Sheringham Shoal and Dudgeon Offshore Wind Farm Extension Projects

Apportioning and Habitats Regulations Assessment
Updates Technical Note (Revision D) (Clean)

Revision D

Document Reference: 13.3

Offshore Works Plans (without prejudice) – scenario
1(c), 1(d), 2, 3

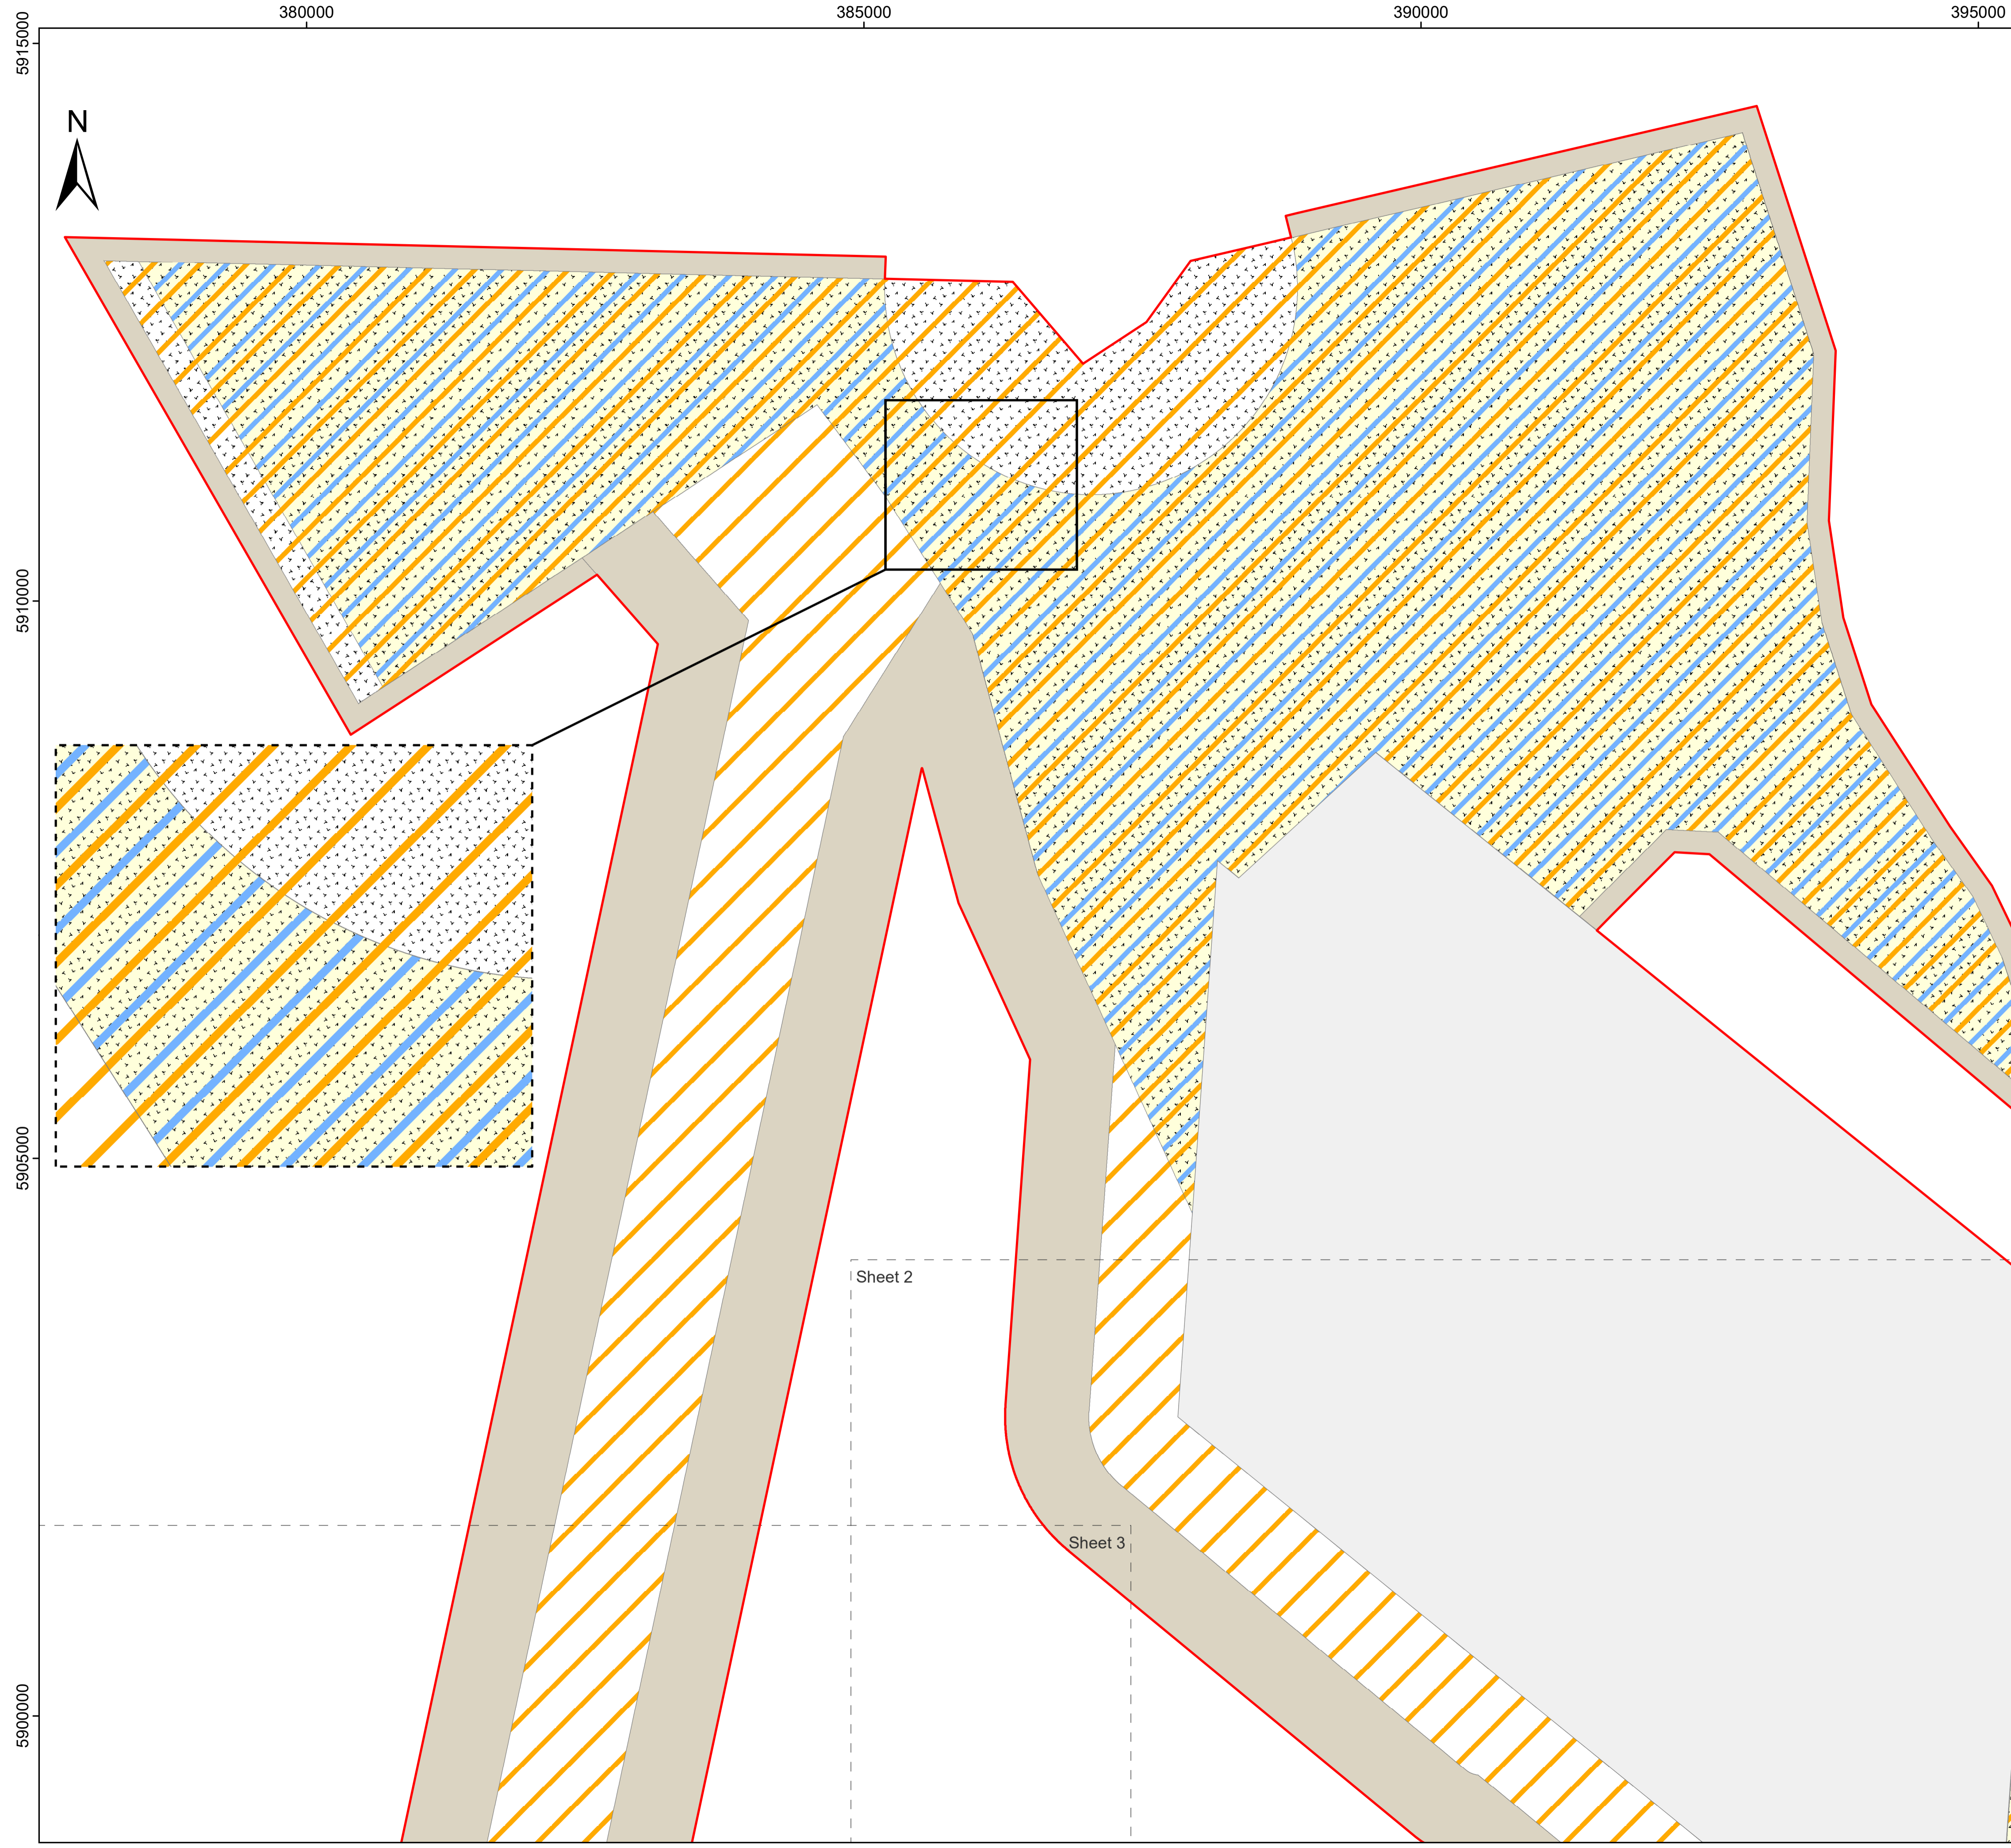
3. In addition, the Applicant can confirm that, following discussions with Natural England on 26 June 2023, and notwithstanding its conclusions that AEol on the red-throated diver feature of the Greater Wash SPA can be ruled out (**Section 13**), the Applicant has committed to the following mitigation:

- Turbine restriction zone within the southeast corner of the SEP wind farm site resulting in an approximate 4.5% reduction in buildable area of SEP (as secured through an update to the **Works Plans (Offshore) (Revision C)** [document reference 2.7]); and
